**DEVIATION REQUEST
AND DECISION FORM IN
ASSOCIATION WITH A
REQUEST FOR A PUD
MODIFICATION FROM
THE ECM**

A deviation from the standards of or in Section **EMC 2.24.3.7 (figure 2-17), Table 2-7** of the Engineering Criteria Manual (ECM) is requested.

PUD Mod.3_v1.pdf Markup Summary

No. [PUDSP-22-006](#)
Subject: Text Box
Page Label: 1
Author: CDurham
Date: 7/11/2022 5:45:40 PM
Status:
Color: ■
Layer:
Space:

**PRIVATE ROAD (30' WIDE TRACT)**

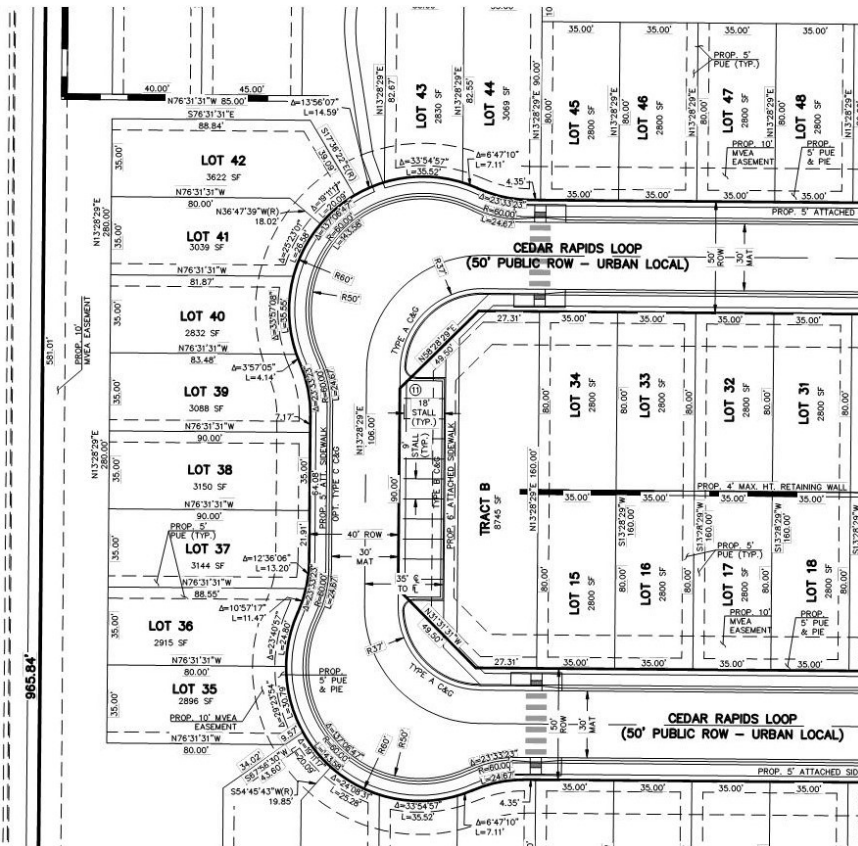
Include a copy of the proposed section & an overall map identifying the streets requesting to be modified
